Re: Submission to proposed Smithfield Materials Recycling Facility at 132-144 Warren Road, Smithfield (SSD-19425495)

Re: 132-144 Warren Road, Smithfield – Proposed Smithfield Recycle Centre
Application No. SSD-19425495
TRAFFIX Peer Review

**ATTACHMENT F**  
**SWEPT PATH ANALYSIS (12.5 m HRV AND 19 M SEMI TRAILER)**

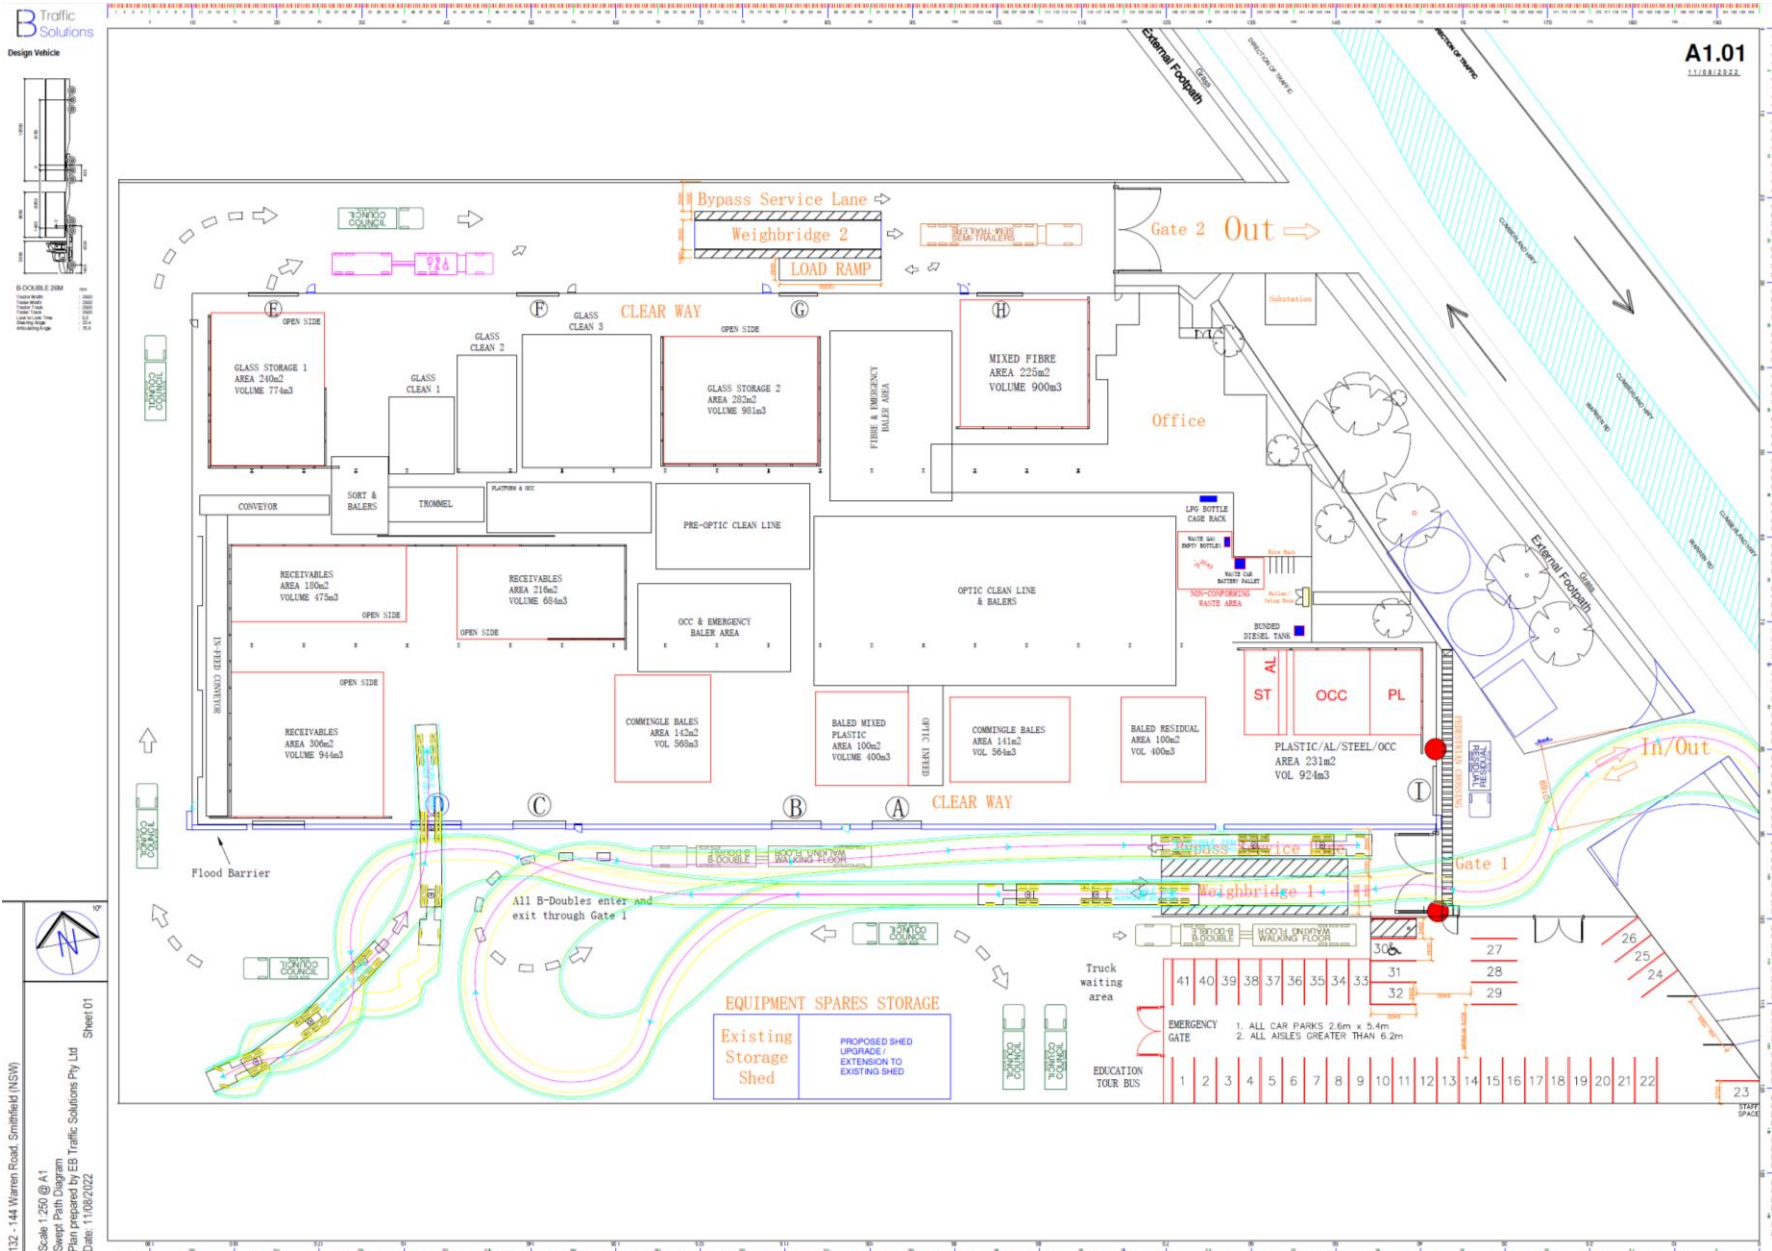
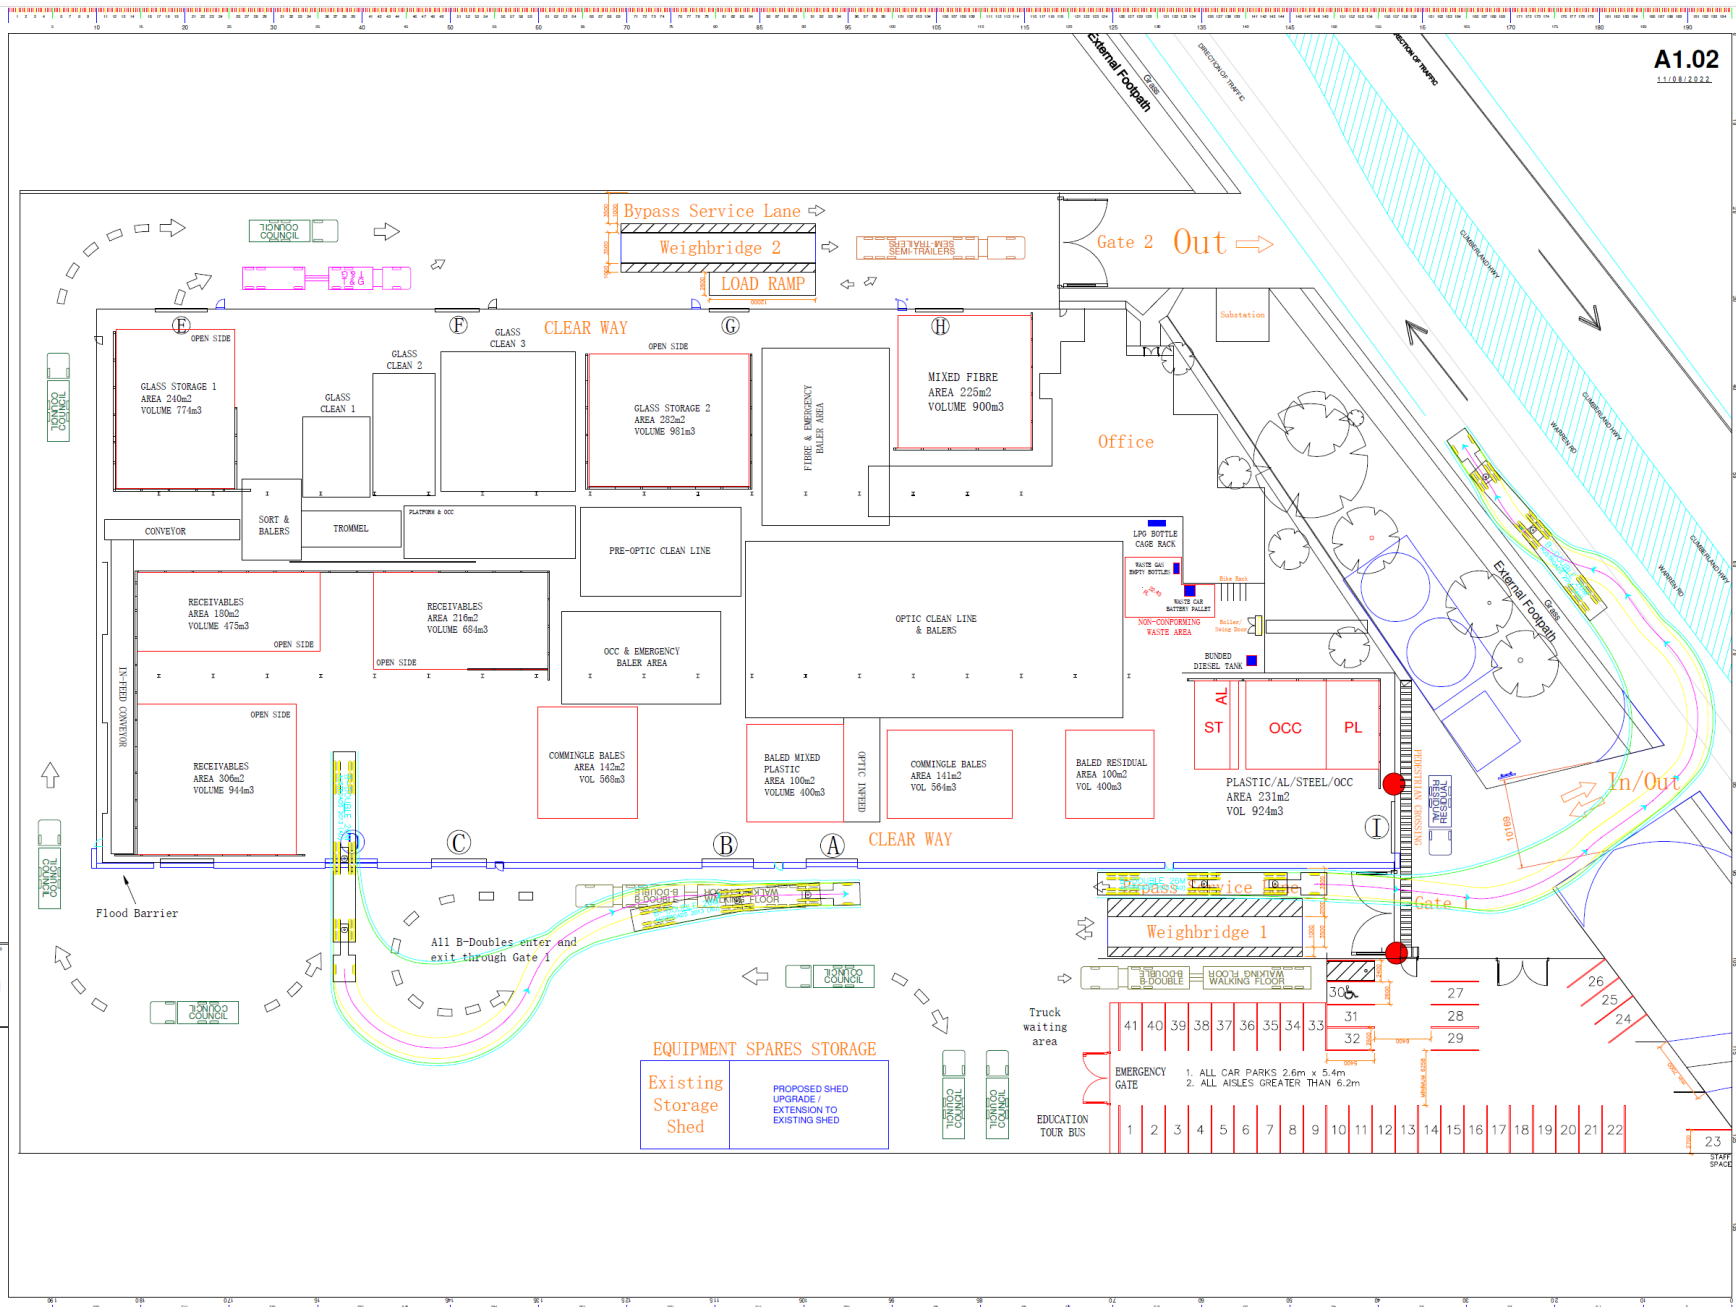
- The TIA acknowledges the current AS 2890.2 (2018) but references 19m semi-trailers, which is in the former standard that has now been superseded, and therefore all relevant assessments must be updated to ensure manoeuvring areas are satisfactorily designed for 20m semi-trailers as per current standards. In addition, the review identifies several issues in relation to the swept path analysis. Therefore, the swept path analysis should be revised to satisfy AS 2890.2 (2018) requirements.

A review of the swept path analysis provided in Attachment F & G of the TIA has found the following:

- It is unclear if 600mm vehicle body clearance has been adopted for commercial vehicles in accordance with AS 2890.2 (2018) requirements;
- All semi-trailer swept path analysis needs to be updated to adopt 20m Articulated Vehicles (AVs) in accordance with AS 2890.2 (2018) requirements;

- The eastern combined entry and exit driveway shall be designed in accordance with Figure 3.2 of AS 2890.2 (2018) accommodating 26m B-Double design vehicle;

- The swept path analysis fails to demonstrate how a vehicle entering the eastern commercial driveway will be able to pass another commercial vehicle waiting to exit, resulting the truck having to stop on a classified State Road whilst waiting for truck on the driveway to exit, this is then complicated by the exiting truck needing to cross over three (3) traffic lanes and how they are able to safely enter the road with limited sight distance. Any departure to sight distance requirements specified in AS 2890.2 (2018) must be justified to ensure safe and efficient vehicular access / egress can be achieved via a classified State Road to the satisfaction of TfNSW;

- Swept paths analysis should be provided to demonstrate satisfactory access / egress to every loading dock whilst not impeding access / egress to adjacent loading docks and the circulation driveway;

- It is unrealistic to expect 26m B-double will be able to reverse as shown in the provided swept path analysis unless video evidence can be provided, as such, adequate decoupling areas must be provided for 26m B-double so they can decouple the second trailer and be reversed in as standard AVs to achieve safe and satisfactory operation in accordance with best industry practice;

- The 26m B-double exiting the eastern commercial driveway takes up the entire driveway and all three (3) traffic lanes on Warren Road, it is unclear how this would be acceptable to TfNSW;
- The two-way traffic on the eastern portion of the site involving AVs and B-doubles is chaotic and operational management measures should be provided to ensure safe on-site operation; and
- The 19m AV swept path exiting the western driveway crosses over four (4) lanes of traffic and is unclear how this would be acceptable to TfNSW, noting it will need to be updated to adopt a 20m AV as per AS 2890.2 (2018).
